A14 Cambridge to Huntingdon Improvement Scheme – TR010015

Examining Authority's Second Written Questions – 29 July 2015

Drawing title: **LAND PLANS REGULATION 5(2)(i) SHEET 28 OF 40**

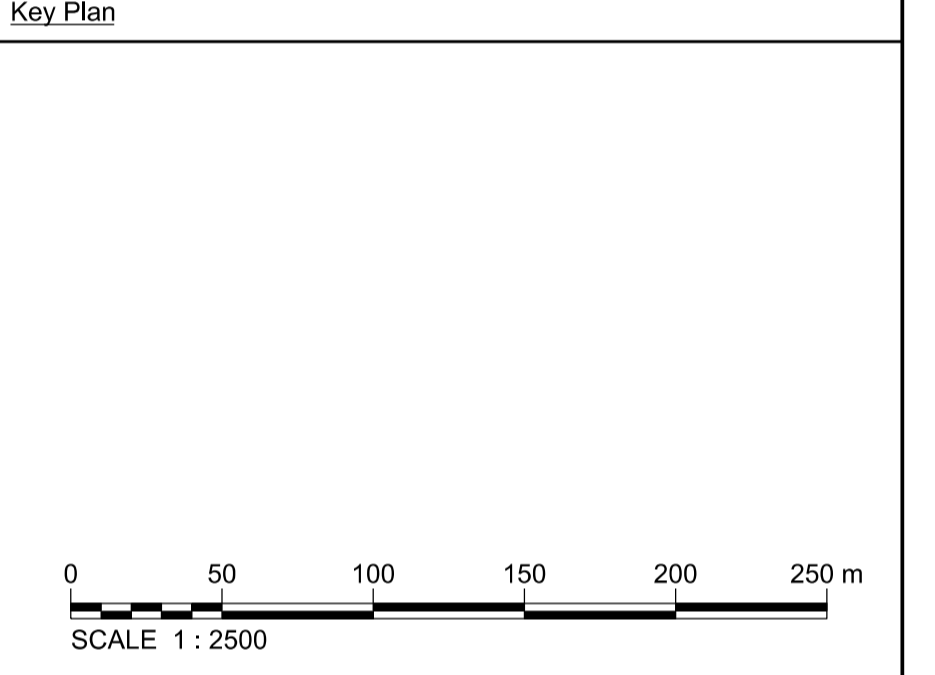
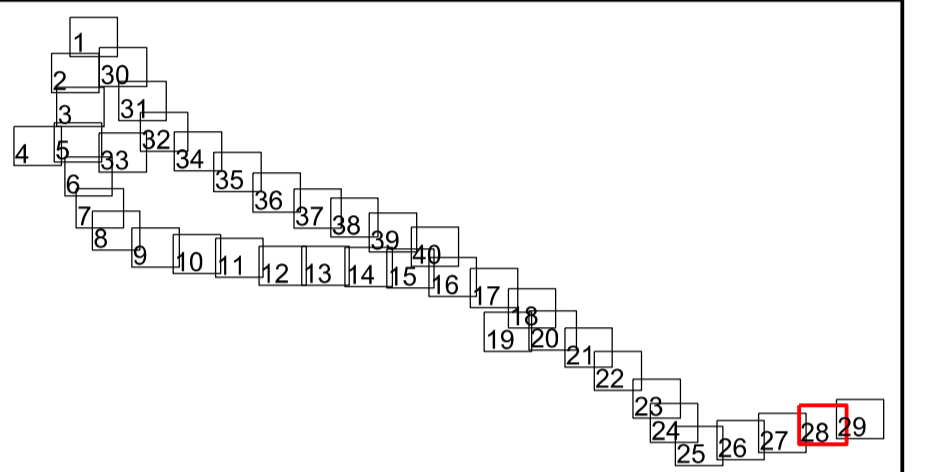
Q2.4.2	Applicant	Land plans 28 (plot 28/7) and 29 (plots 29/4,29/7) show Land to be acquired for landscaping. The scale of the Land Plans make it difficult to ascertain the extent of the land taken. Both Napp Pharmaceuticals and Bard Pharmaceuticals are concerned that the proposed land take interferes with fibre optic cables laid in the ground, appears unacceptably close to the corner of one of their buildings and could remove up to 90 car parking spaces adjacent to their building Unit 196. The ExA accompanied site visit could not clarify the matter. Could the applicant look at the detailed design proposals for this area if necessary in collaboration with the parties concerned and advise the ExA whether the fears of the parties are warranted and the land take will have the effects outlined above or otherwise.
Q2.4.3	Applicant Cambridge City Council	On our accompanied site visit to Cambridge crematorium on the 17th July 2015 the ExA noted that the proposed new entrance to the crematorium close to the north west corner is located between the Muslim burial area and an area of woodland or garden used for the scattering of ashes and the planting of trees. It appeared to the ExA that the proposal would substantially interfere with the area where ashes are scattered and trees are planted.
